RE: Ceja Vista Unit 1A, 1B, 1C, 2A, 2B, & C
Amended Drainage Management Plan
Stamp Date: 04/24/18
Hydrology File: P09D002E

PO Box 1293 Based upon the information provided in your resubmittal received 04/25/18, the Amended
Drainage Management Plan is approved for action by the DRB on the Preliminary Plat.

Dennis Chavez Roadside Swale- West of 98th Street-Preliminary Design

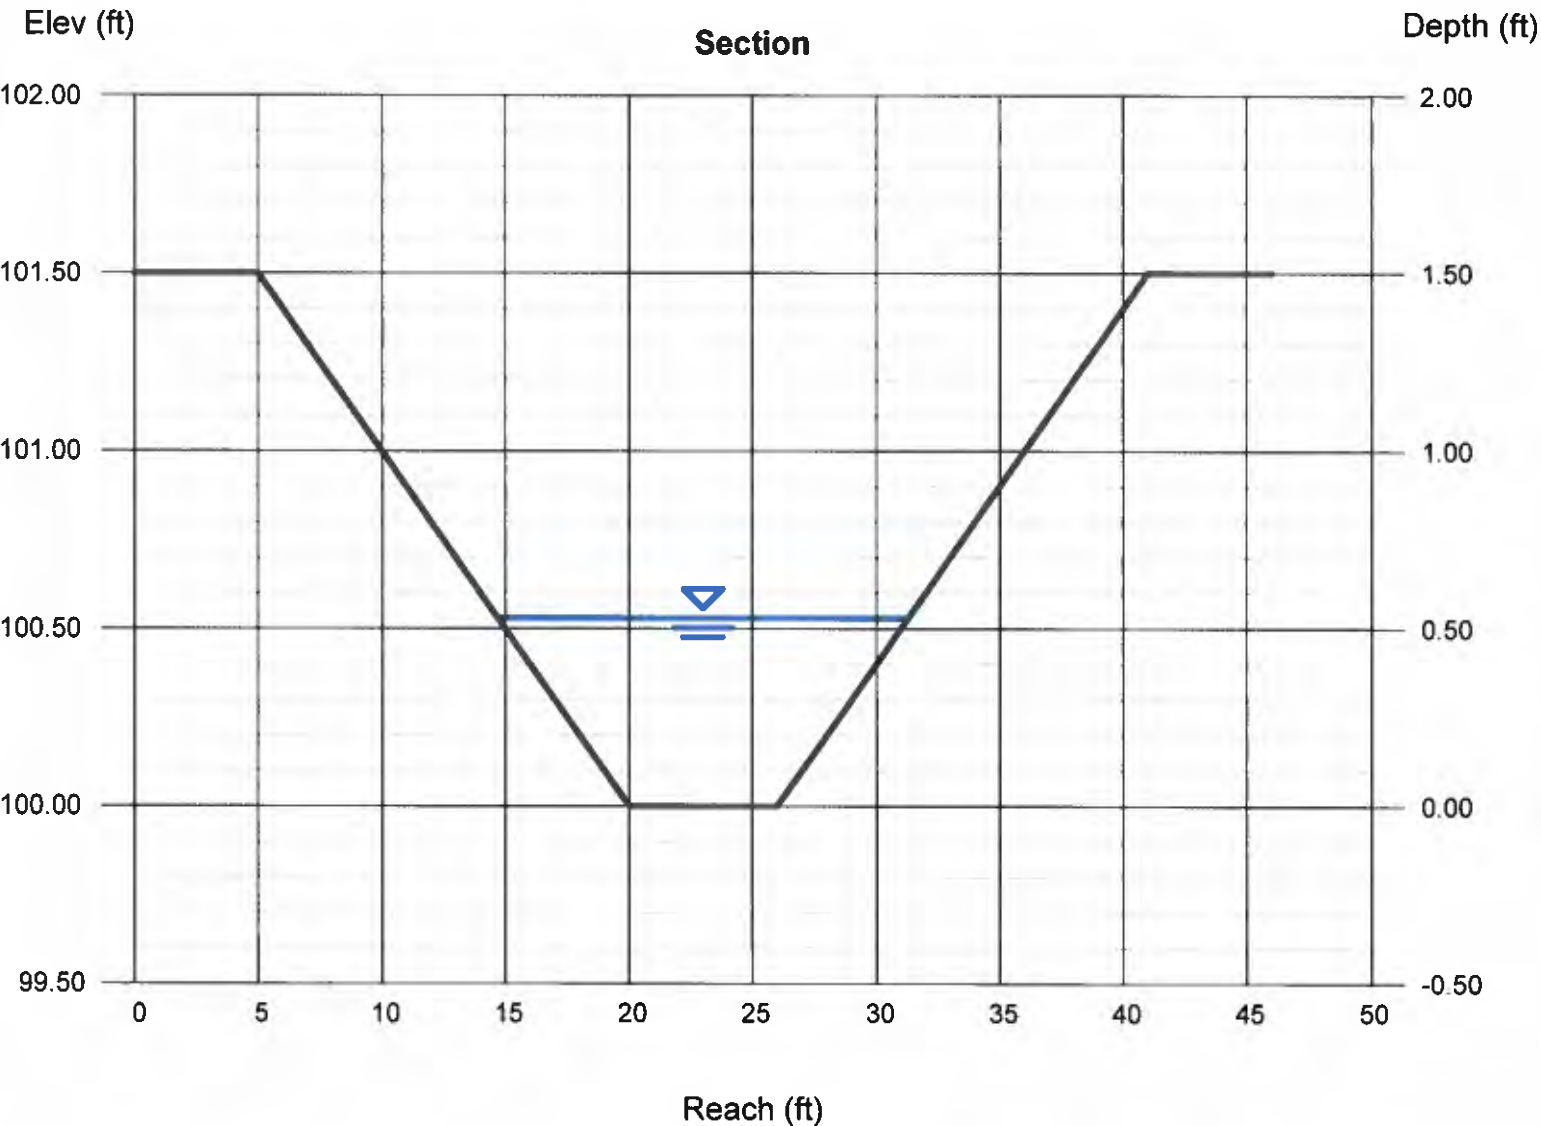
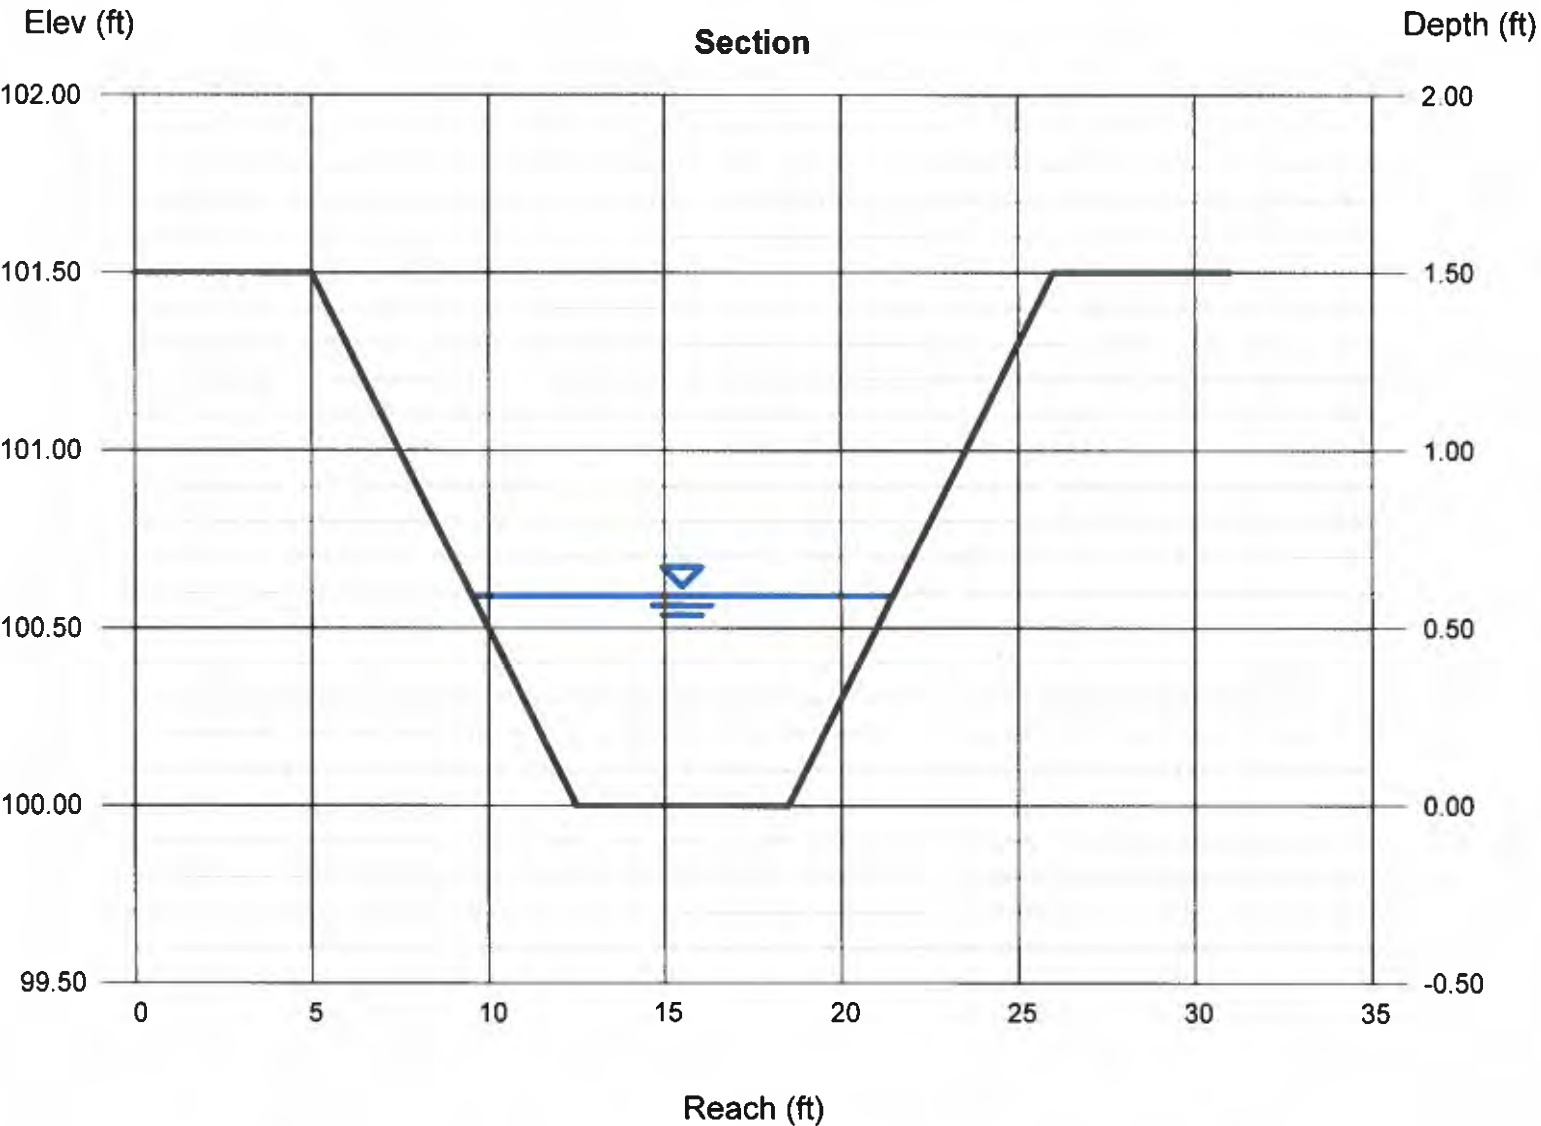
- NM 87103 1. Please provide a section along Dennis Chavez showing the proposed concrete
Channel per NMDOT's acceptance of the design. The trapezoidal section
calculations may need to be revised per the final design.
- www.cabq.gov 2. For the public drainage channel and temporary retention pond in Bernalillo
County, a Permanent Public Drainage Easement granted to the City of
Albuquerque and an Agreement and Covenant for said public drainage channel
and temporary retention pond will have to be recorded.
3. Please provide a Drainage Covenant per Chapter 17 of the DPM for each
temporary pond on Tract RR-3-A-1, RR-3-A-2, and RR-3-B. If the Grading and
Drainage Plans for the proposed development on Tract RR-3-A-2 is approved
before the recording of the Drainage Covenant, then the construction of the
temporary pond and therefore a Drainage Covenant are not needed for Tract RR-
3-A-2.
